Our ref: PL00795841
Interested party ref: [REDACTED]

Telephone: 0117 975 0742
9 April 2026

**Lime Down Solar Project Nationally Significant Infrastructure Project
Environmental Statement Technical Addendum to Chapter 12: Cultural Heritage**

Title:
Figure 2-2-4: Field Boundaries and Numbering
Lime Down D

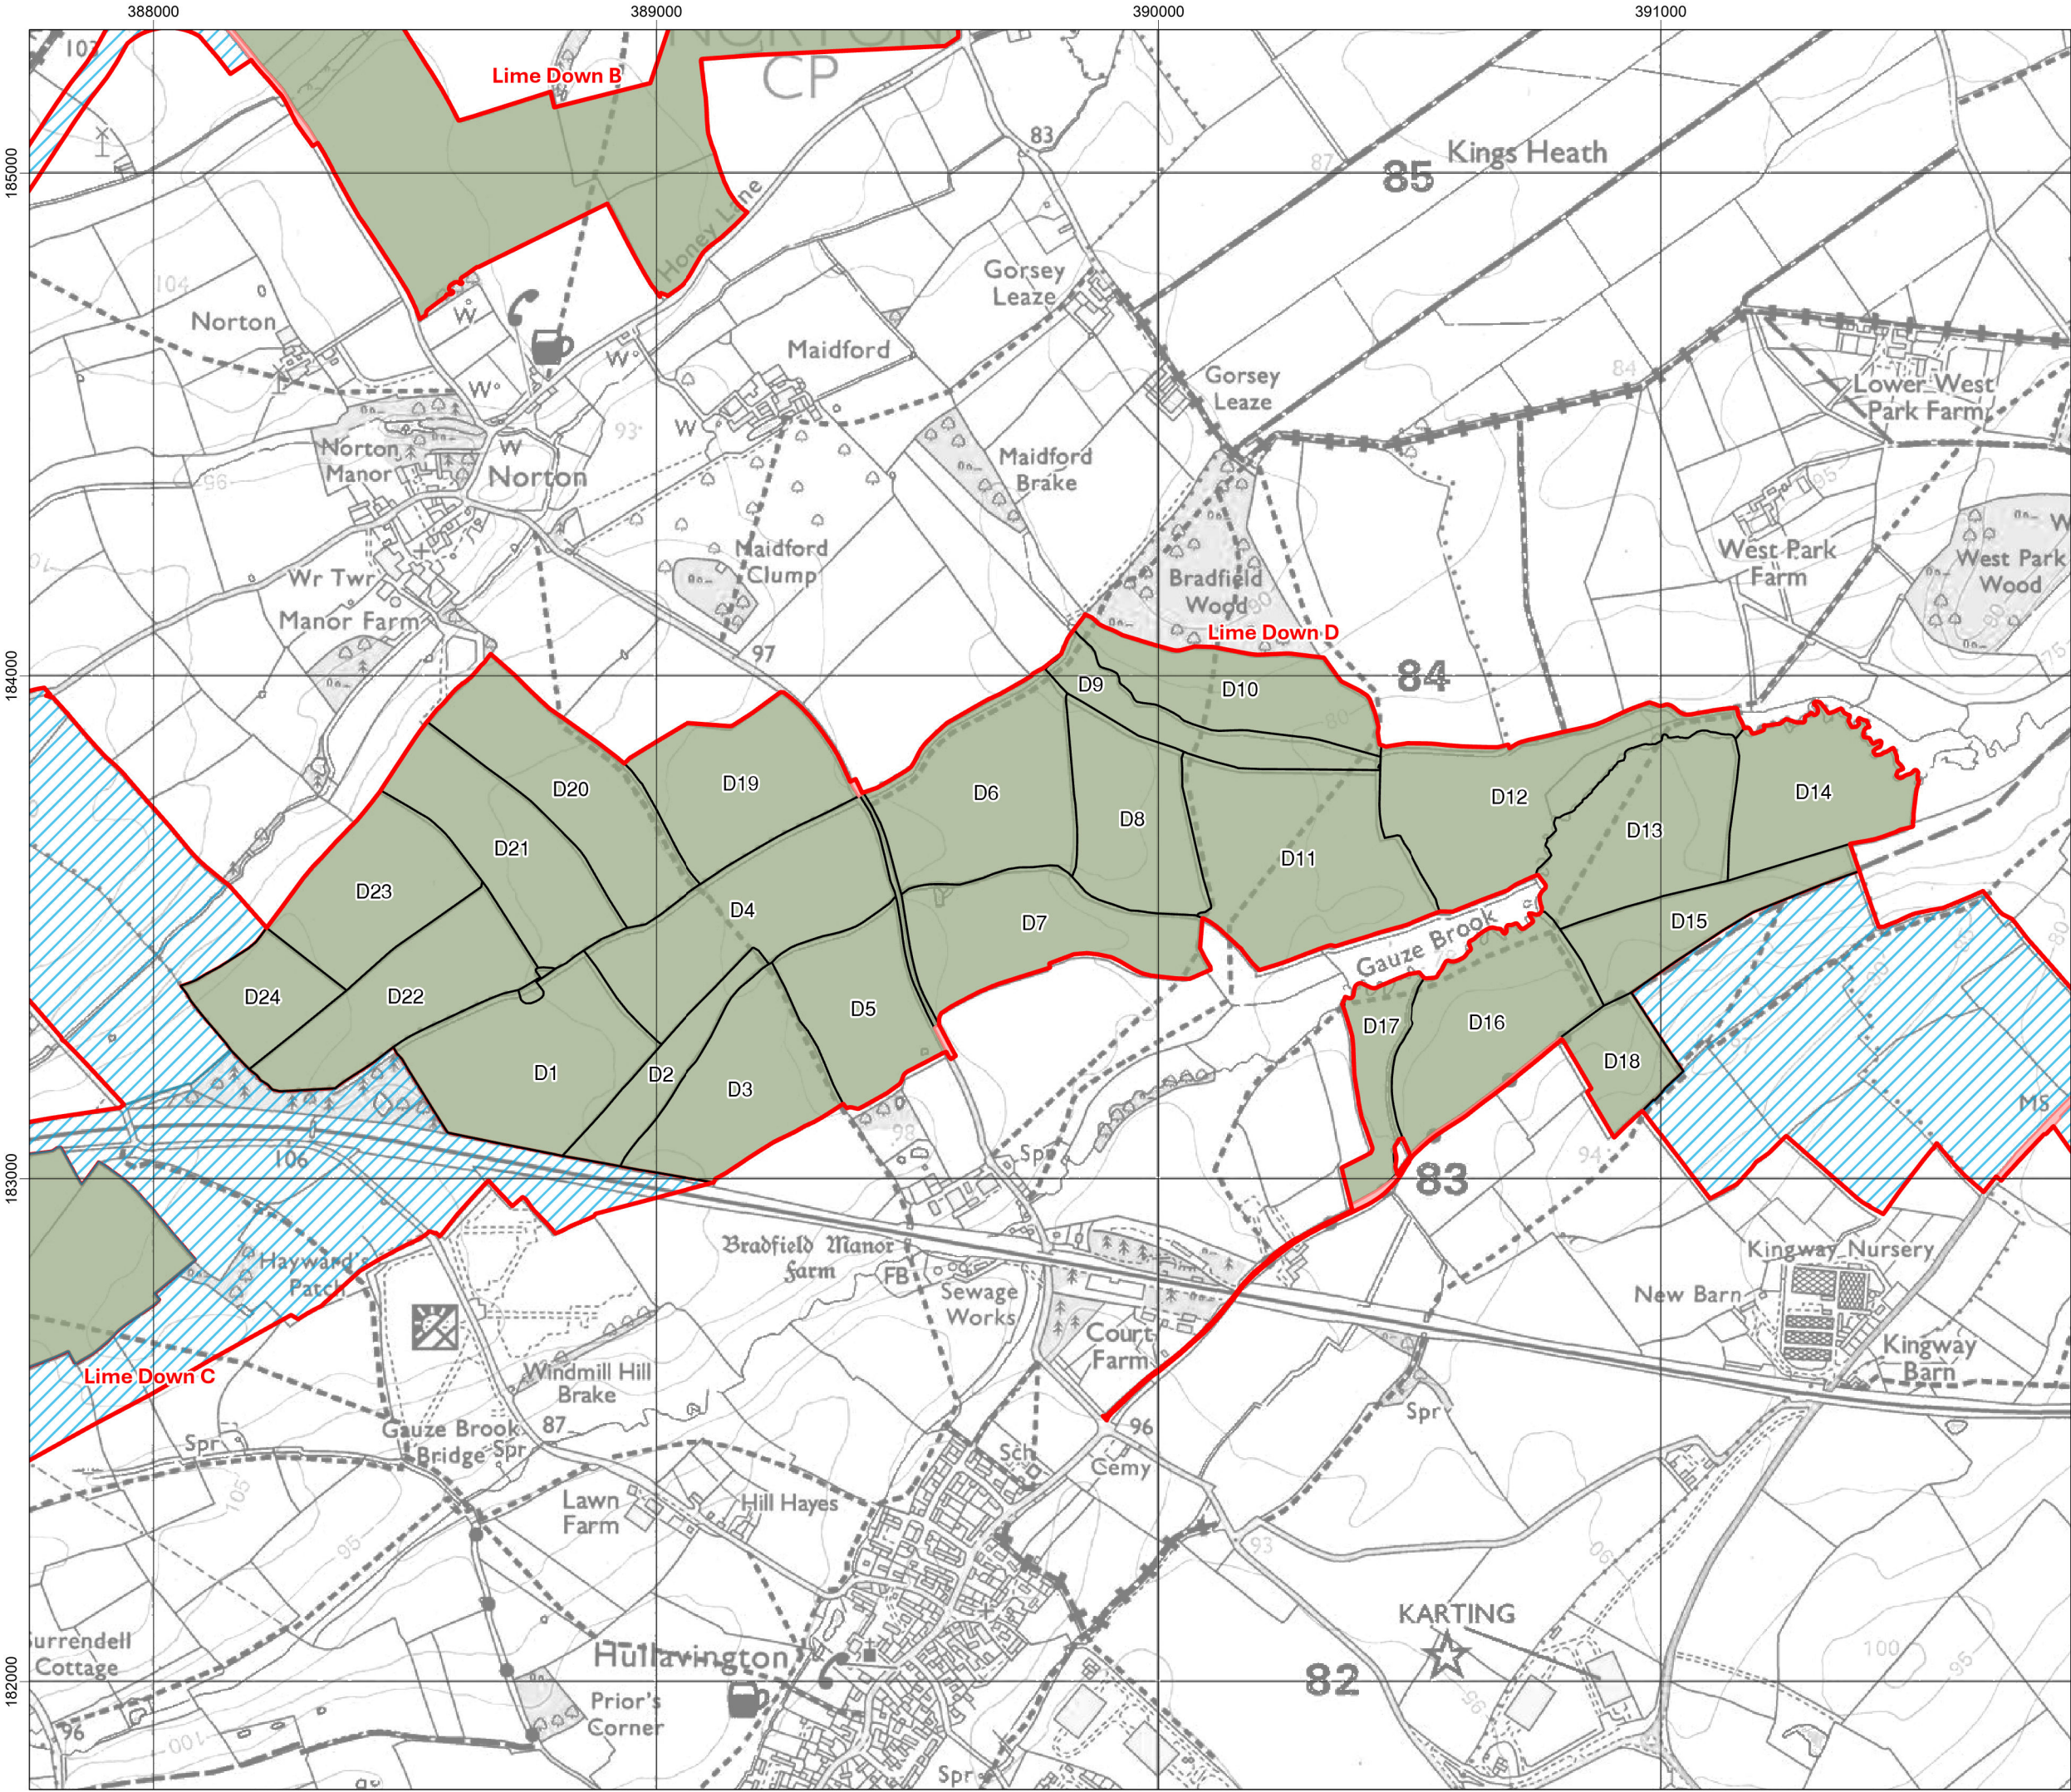
We advise that there is potential for the harm to be minimised and mitigated through some additional planting along southern boundaries of the application site, which may potentially provide screening of the visible areas of D2 and D3, D5. It seems unlikely that D20 on rising topography would be able to be screened, but as this site is further from the Manor, the harm would be minimised.

Title: Figure 12-1-4: Designated and Non-Designated Heritage Assets Scoped in for Assessment: Lime Down D and Cable Route Corridor

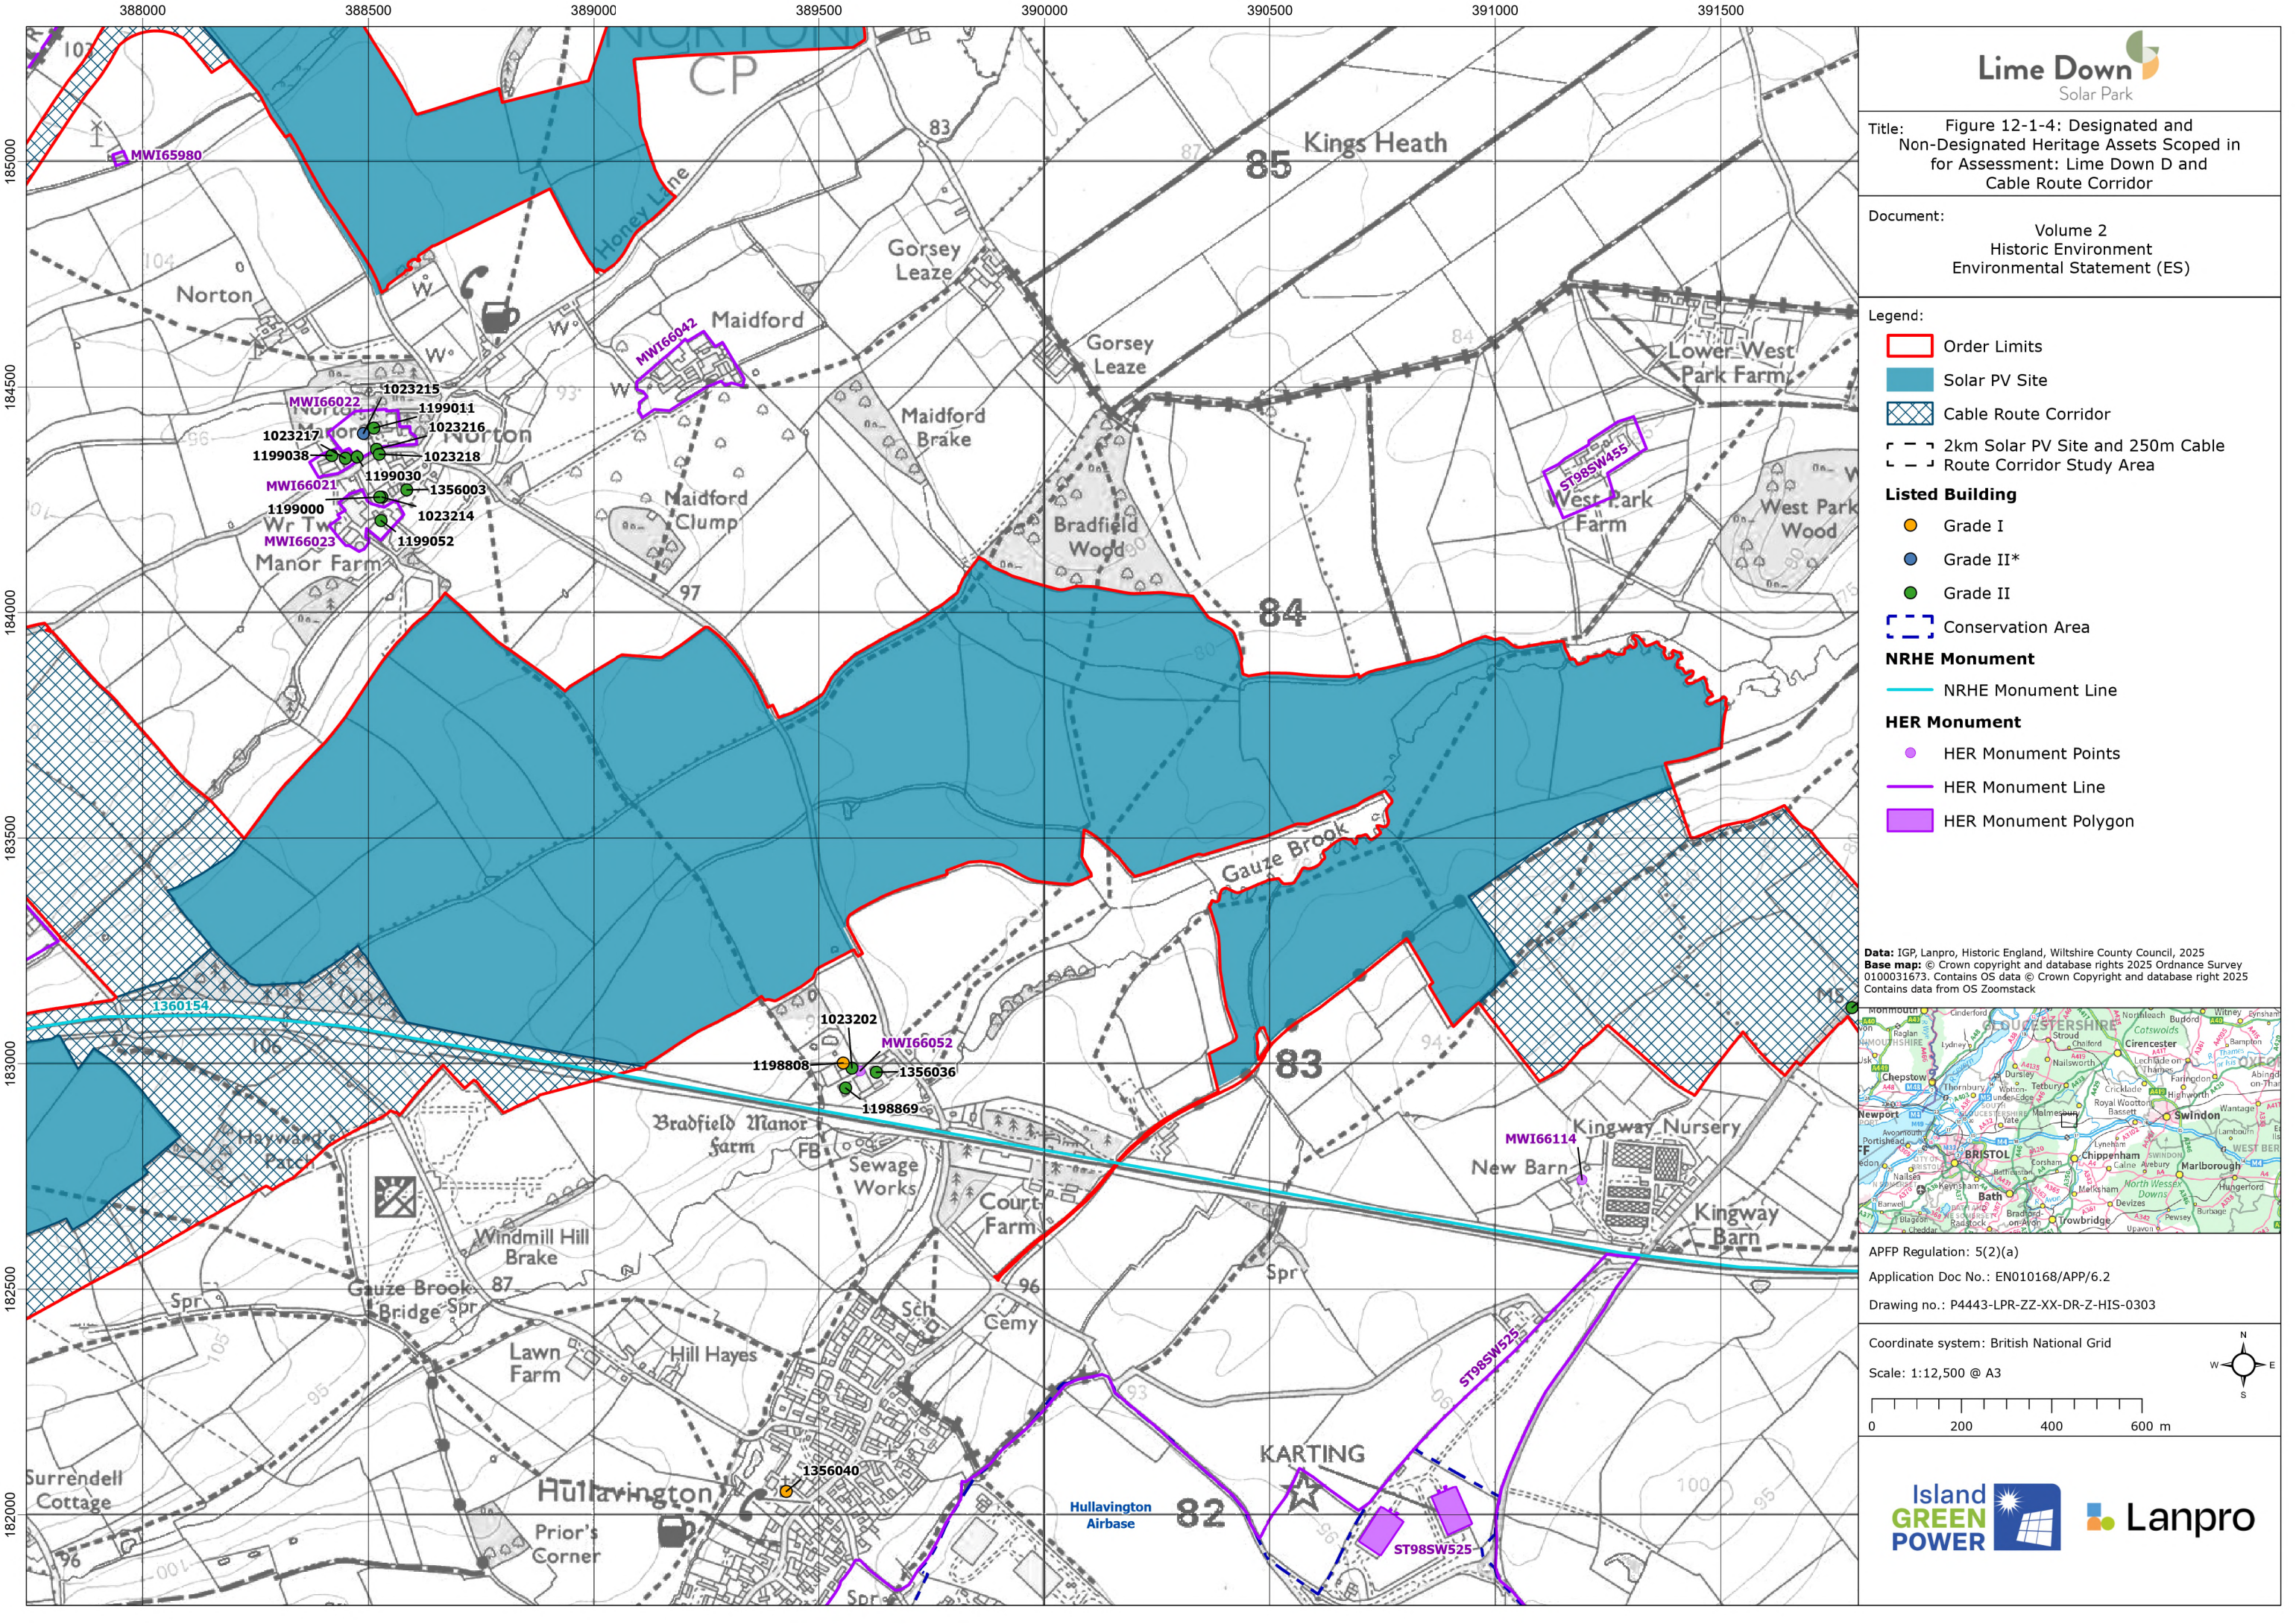
Annex A includes the two visualisations from Bradfield Manor that we have previously requested. These are taken from the first floor of the Grade I Manor, one looking north-west across the southern part of Site D, and the other looking north-east.

The visualisations demonstrate what would be visible from Bradfield Manor. This does not include the profiles of the individual PV panels themselves, but rather areas of land visible from the Manor that would include the proposed development. The primary impact would be the view to the north-west from Bradfield Manor, where the development would be visible within the fields just below the horizon, including parts of D2, D3, D4, D5, D20 and D21. The photo was taken on the 22nd May 2025, and therefore this includes maximum vegetation screening. We advise that winter views may reveal more visibility of the development.

The visualisation provided to the north-east would include some visibility of D11 and D12, but a reduced impact to that shown in the northwest view.

The rural views from a principal first floor room are designed to be experienced as part of the principal outlook from the Manor. The proposed development would introduce an engineered and markedly incongruous appearance to the wider setting of the Manor, which we advise would cause a small degree of harm to its heritage significance.
